From: Ross Anthony <ross.anthony@hbap.org.uk>
Sent: 27 October 2025 09:27
To: _planningadvice
Subject: Application Ref: H13-0876-25 - Seas End Hall, Hall Lane, Moulton Seas End, Spalding, PE12 6LB

Application Ref: H13-0876-25

Proposal: Refurbishment of existing coach house and conversion into entertaining area including extension to include swimming pool.

DRAWING TITLE
Proposed Elevations Of
Coach House

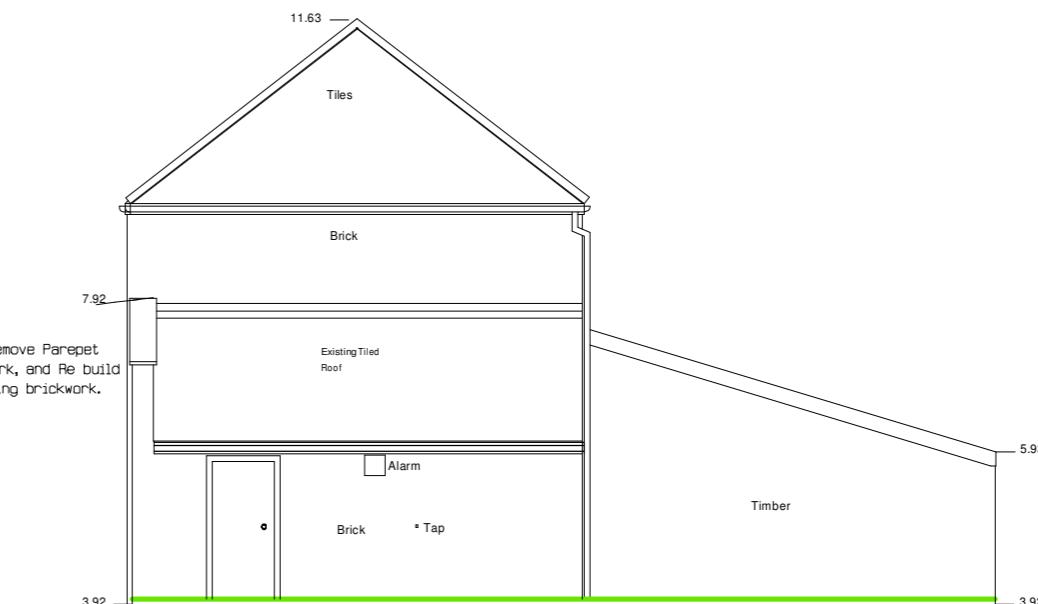
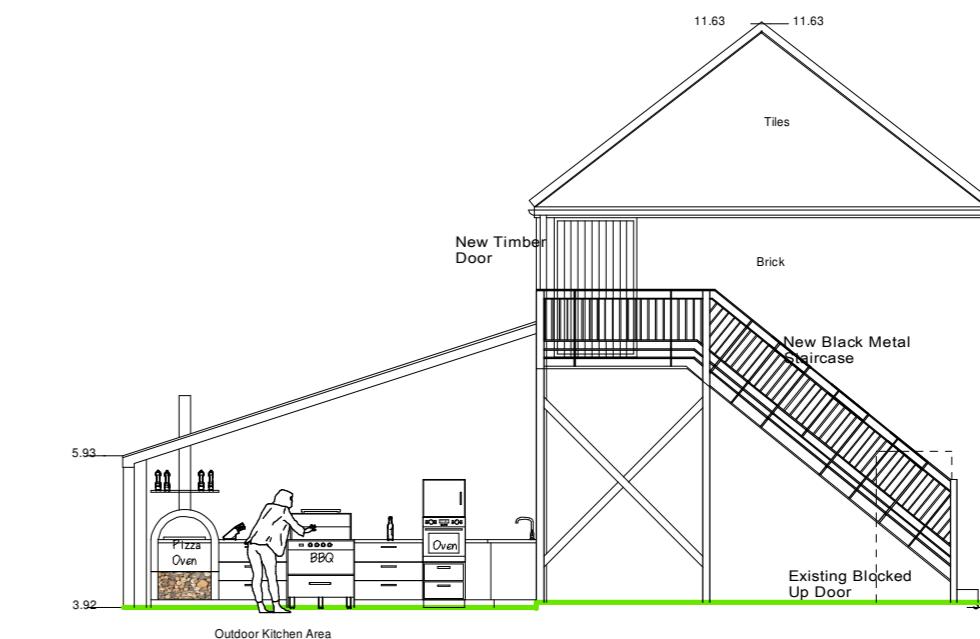
- P15 of the D&AS suggests three oval air vents are to be opened but these are not indicated on the plans. The elevation plans don't show the gabled form of the pool extension – for clarity, the plans should be updated to clearly indicate all changes and proposals.

- Please clarify if these are indeed originally air vents – the external photos of the walls do not appear to have corresponding oval infills. The photos on page 17 shows similar oval features with the original bared metal horse feeders – are the three ovals also feeders not vents? If so, they should be retained as is, not opened.

## Proposed First Floor Plan Coach House

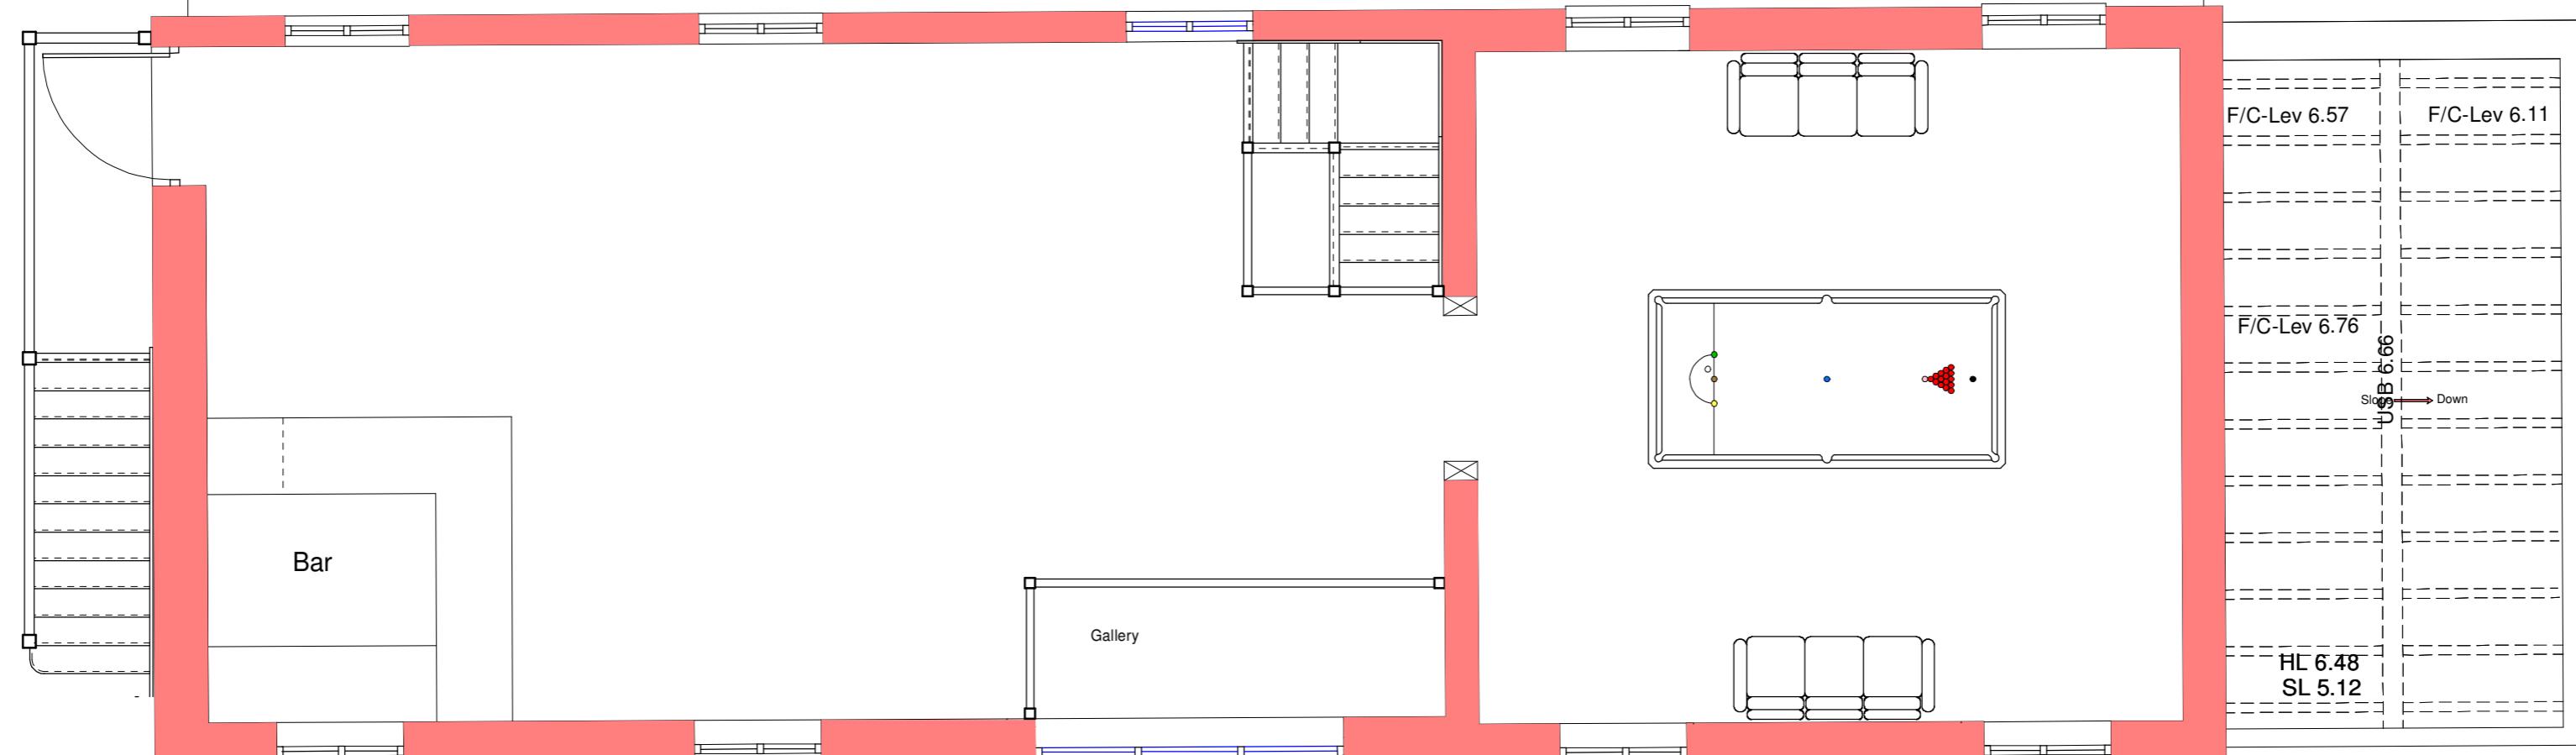
- The first floor is to be replaced – the photos don't suggest the floorboards are all rotten – the presumption should be repair and retain before replacement and a condition survey may be needed to justify their complete replacement. A structural report is needed to confirm if the first floor can support the weight of a pool table – this may be better swapped with one of the ground floor uses.
